Planning application reference AW/181/15/HH

With reference to the above planning application, I wish to place formal objections to the proposed development on the following grounds:

project:	11 Marquis Way - Aldwick		
drawing title:	Proposed Site Plan		
drawing status:	Planning Application		
date:	20 - 06 - 2015	scale at relevant drawing size 1 : 50 (A1) or 1 : 100 (A3)	no: JW131105 - PL10
rev:	B

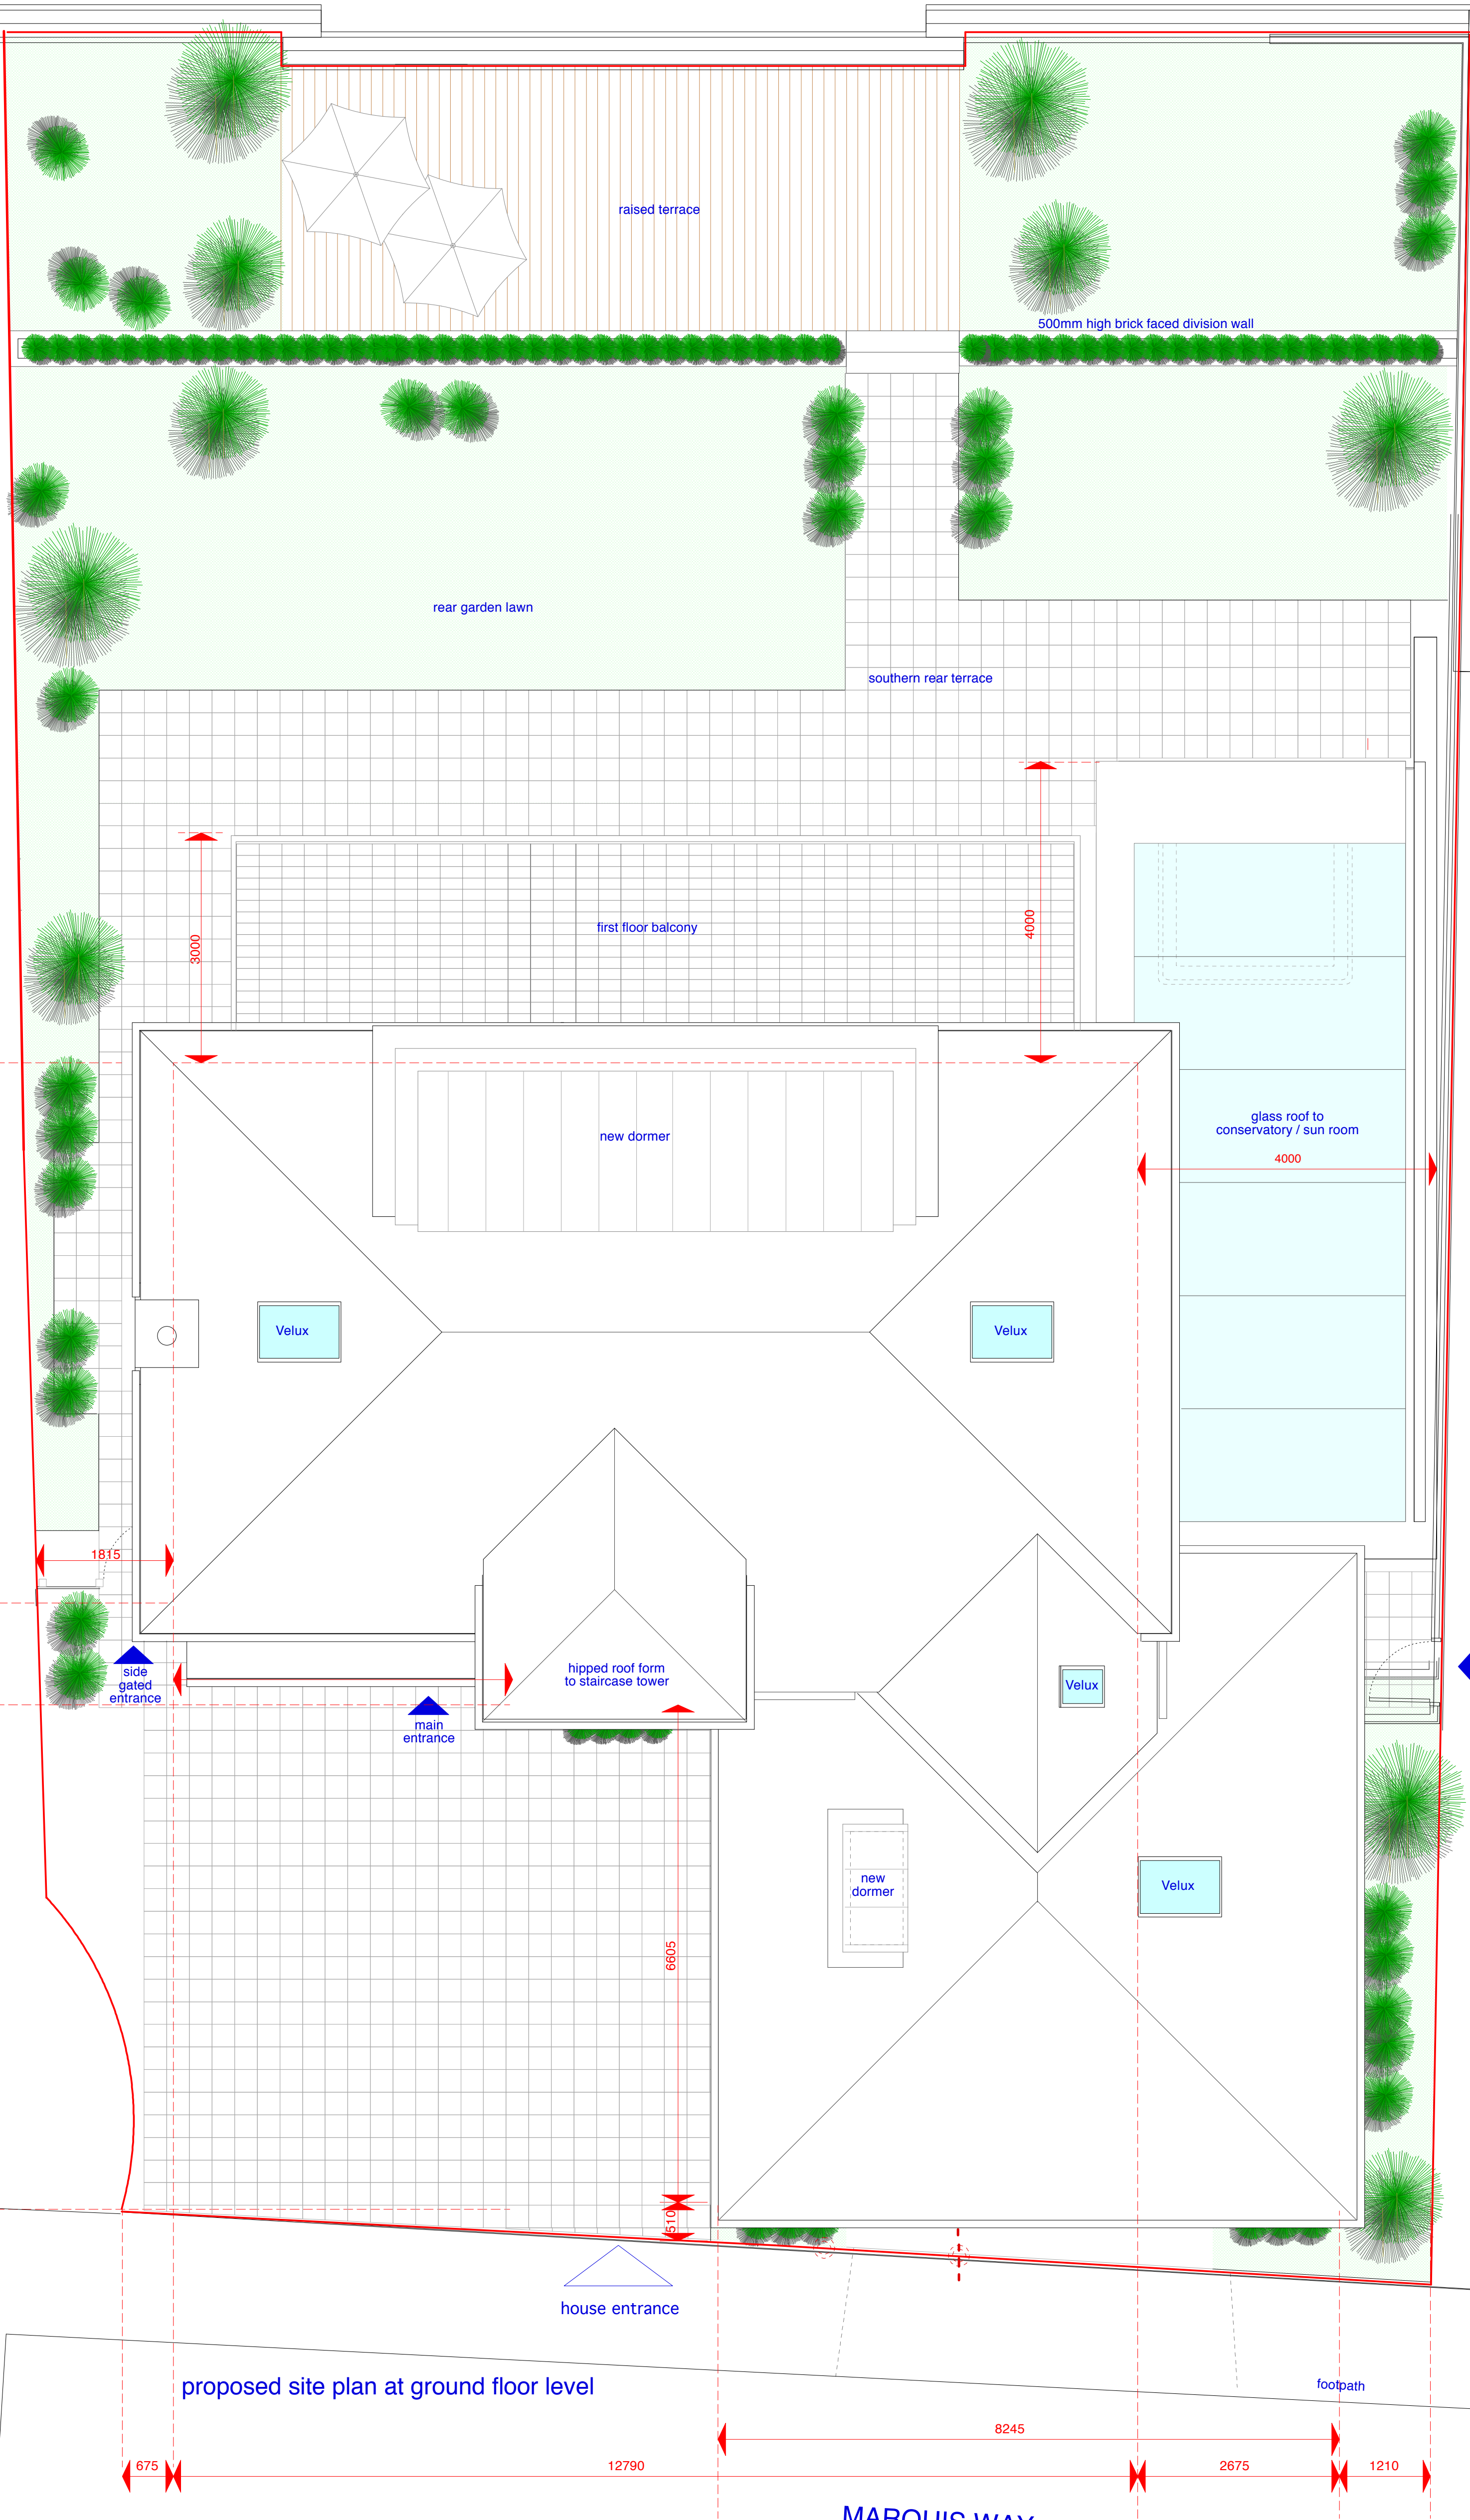
- 3 The proposed ground floor plans would enlarge the property well beyond the building line on the southern aspect. The applicant has cited 'Aldwick Hundred'³ which stands in its own extensive grounds and is at some distance from, and not part of the Marquis Way estate. In a previous planning application⁴, the existing southern building line (taken across the rear of all six seafront properties on the Estate) was rigidly enforced. The applicant's reference to Aldwick Hundred as a building line is therefore totally irrelevant to this application.

- 5 The proposed ground floor plans would extend the property well beyond the building line on the western aspect where the applicant has attempted to create a new building line using the property boundary instead of following the existing building line of the western garage wall. This again changes the look of the estate creating an unbalanced appearance with Number 12 and from the perspective of all properties in the row in front.

western side elevation

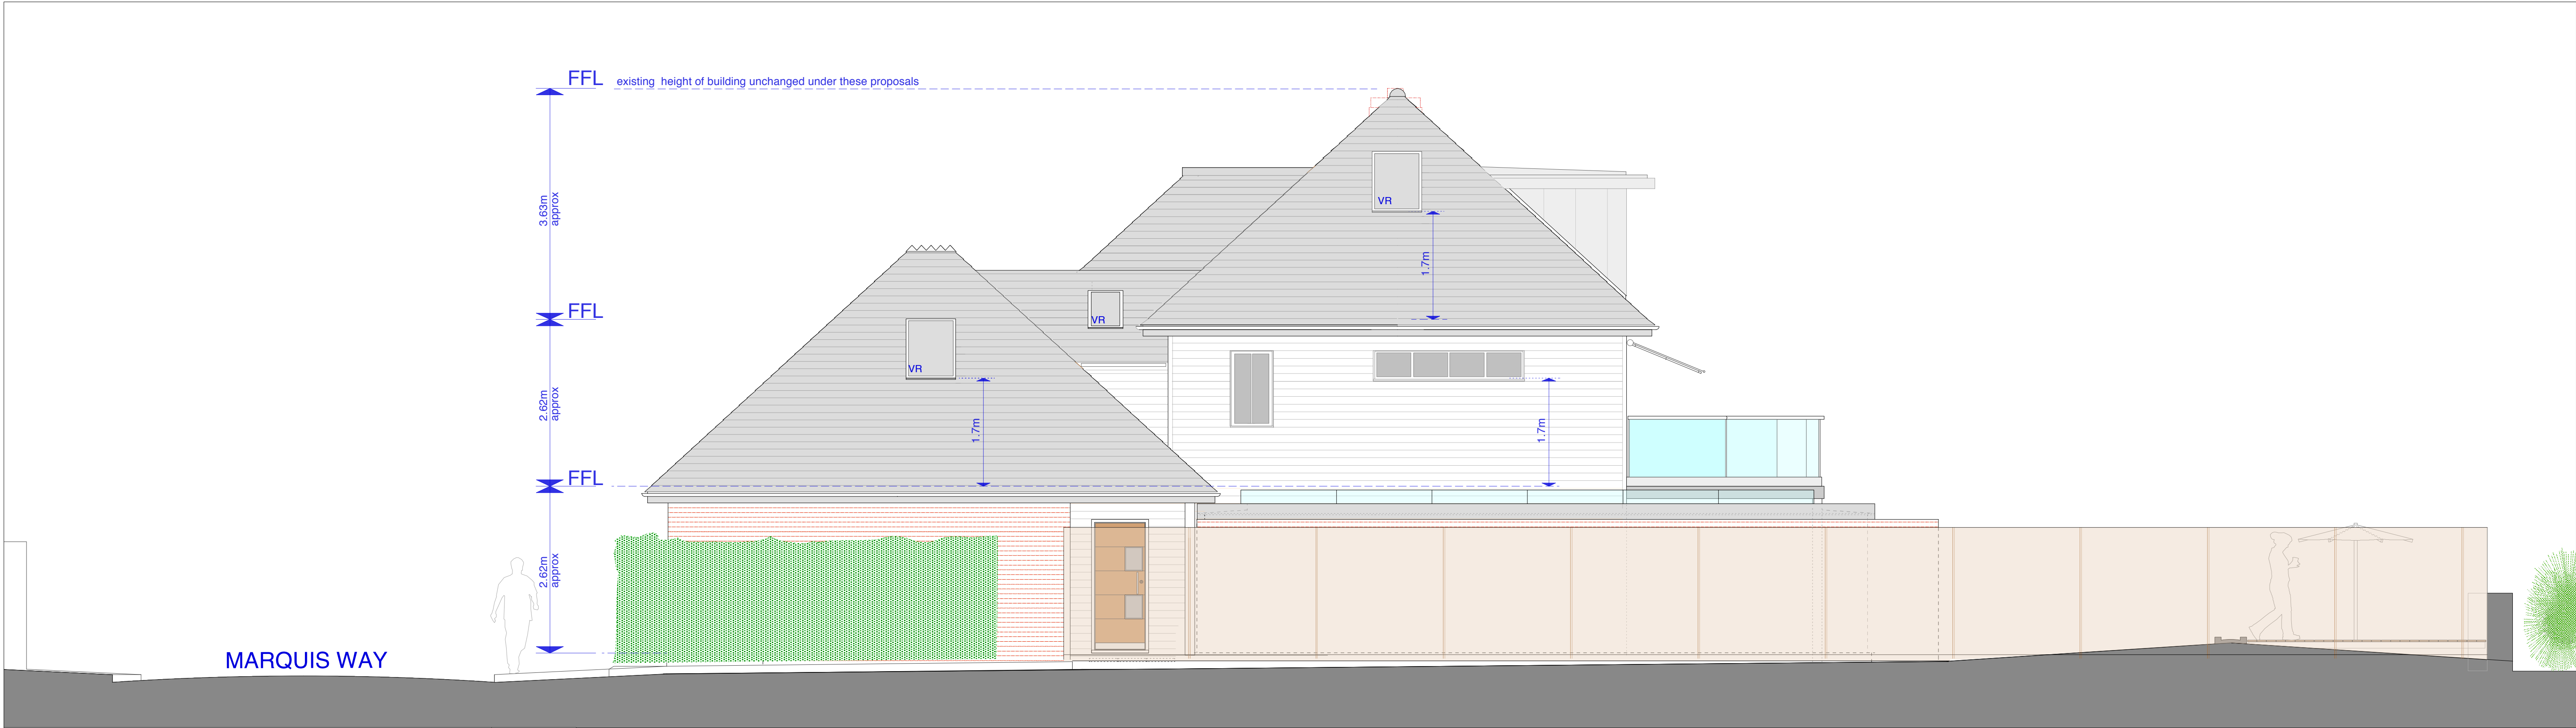
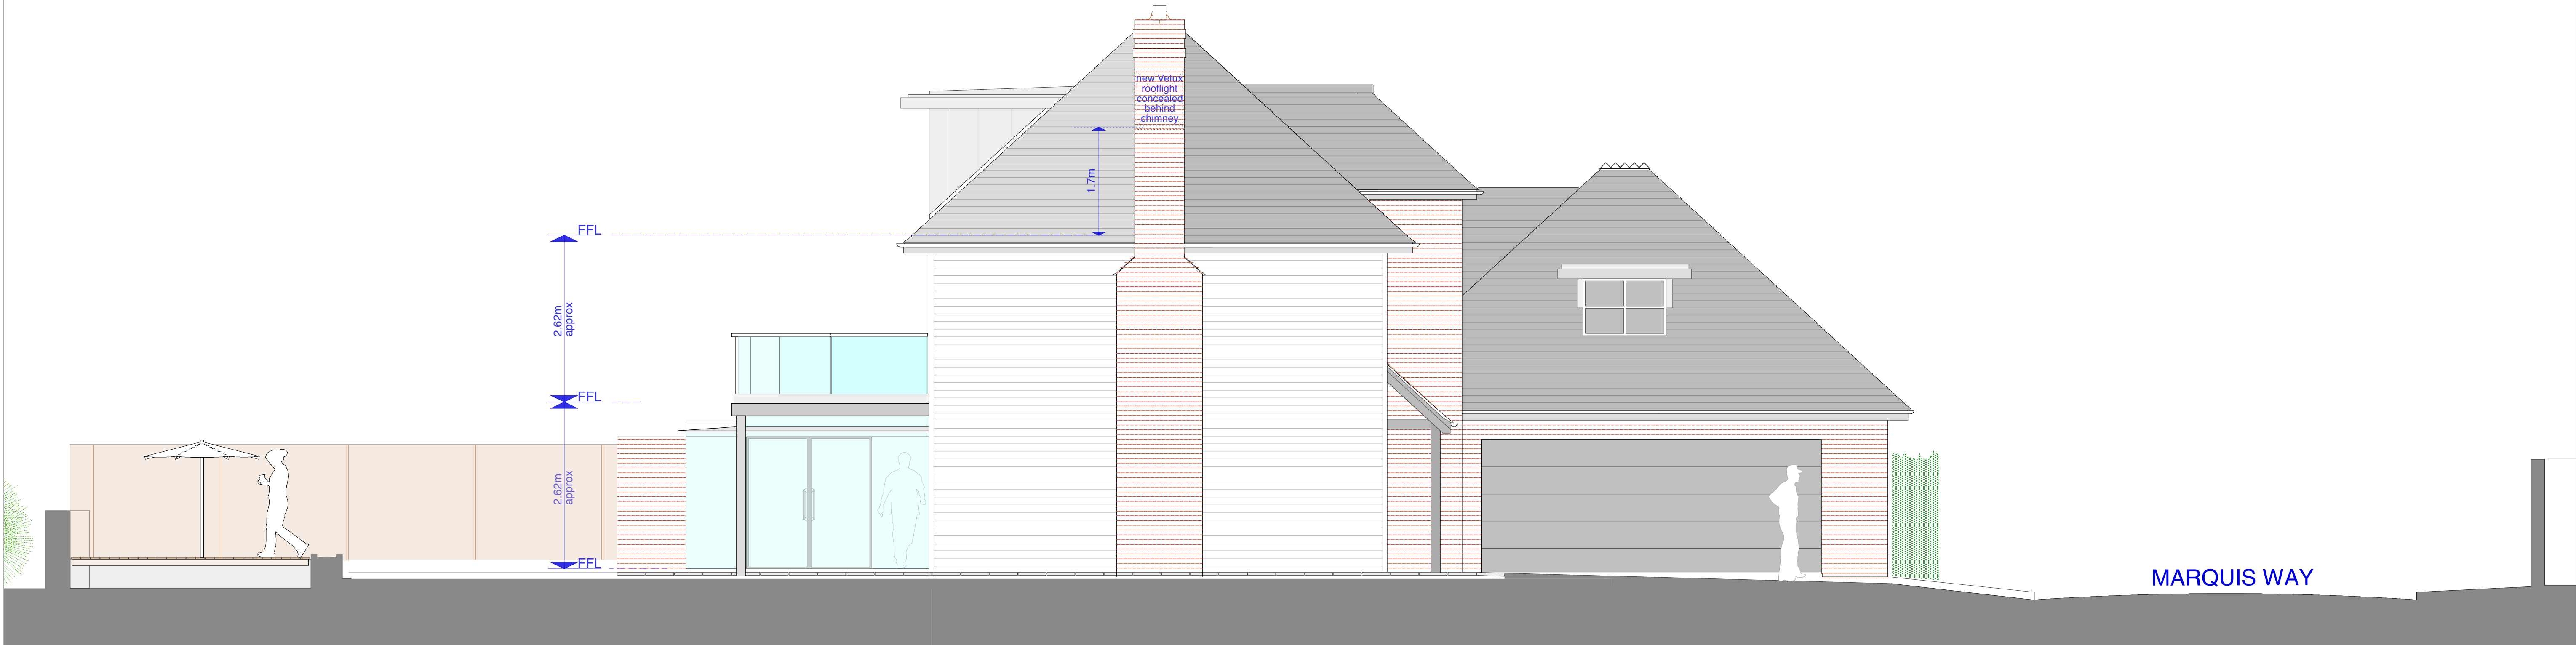
- 7 The proposed first floor high-level window on the western aspect of the house would also provide additional overlooking and directly and intrusively into number 12.
- 8 Additionally, the design would make a five bedroom house into a three bedroom house with one bedroom on each floor, with a lift, suggesting that there may be an intention to convert the property into apartments at a future date. There are no other flats on the estate and limited parking.

Rev D - balcony shape amended - 28.08.2015

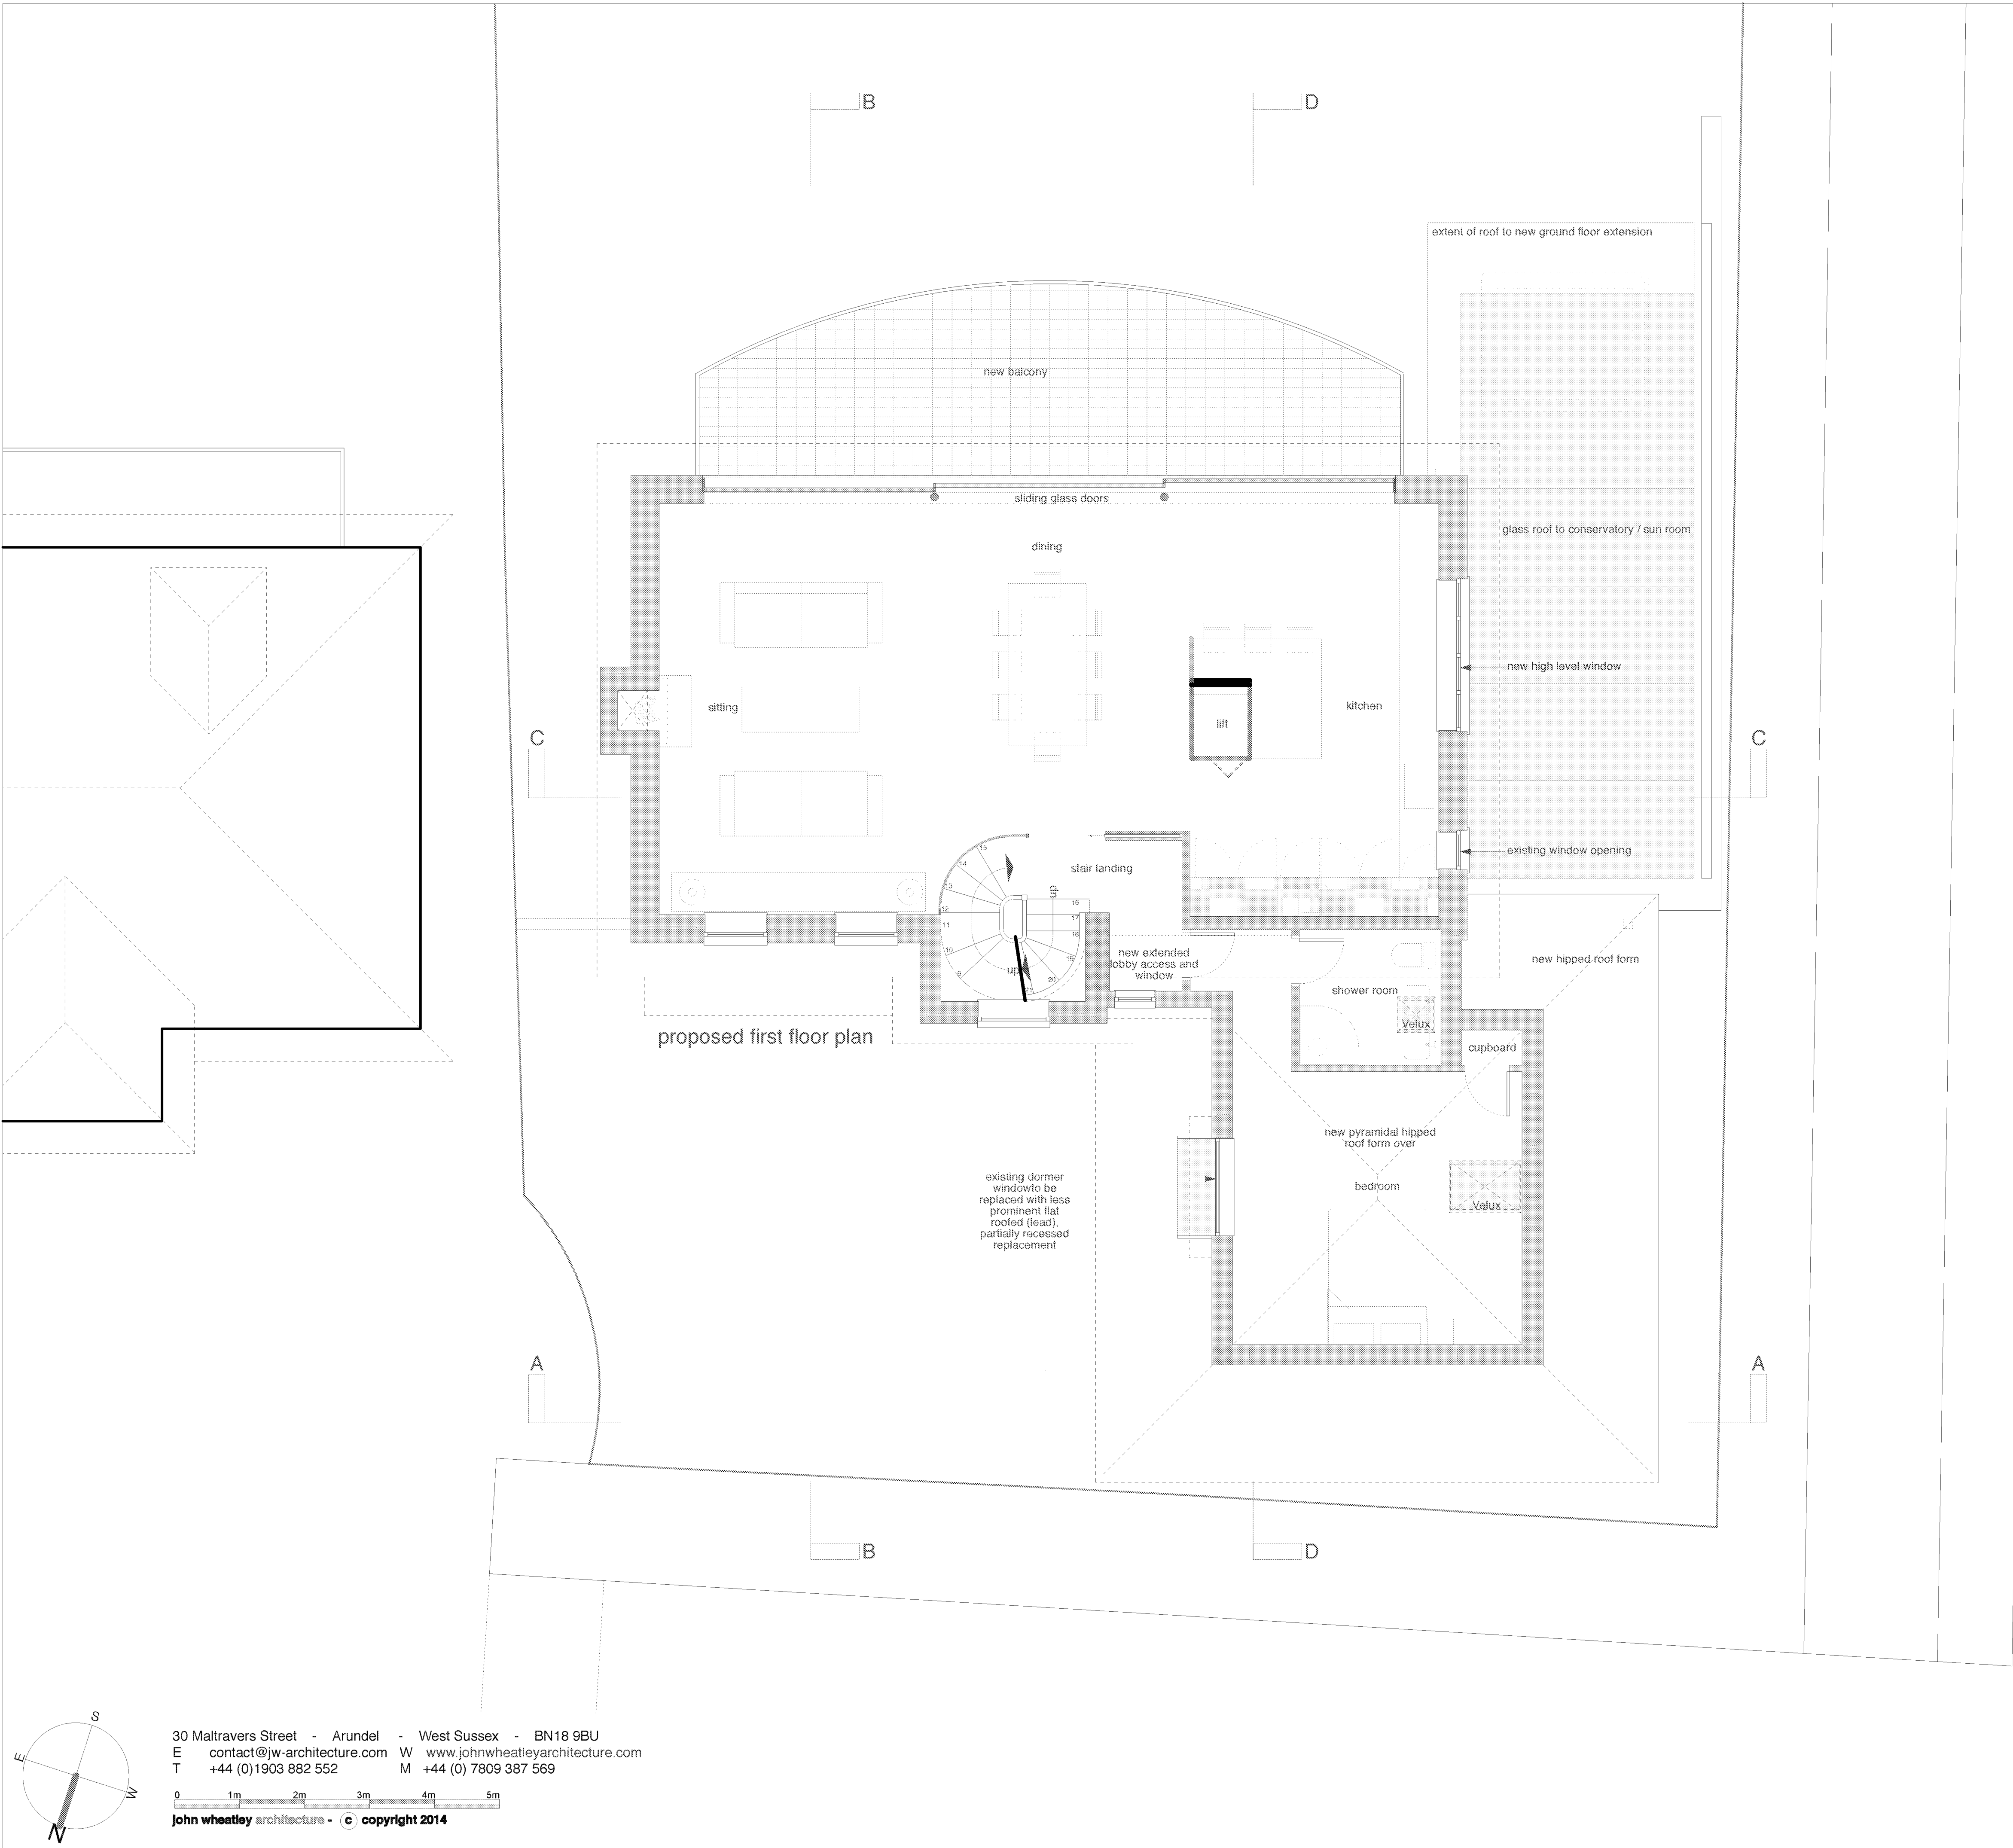
- 6 The proposed first floor balcony depth would be almost doubled and will greatly overlook the properties and invade the privacy on the adjacent houses (numbers 10 and 12, plus at a further distance the other properties in the row). This unreasonable loss of privacy due to overlooking is in contravention of ADC planning policy **DEV19 (iii)**, and is also in breach of an existing Covenant⁵.
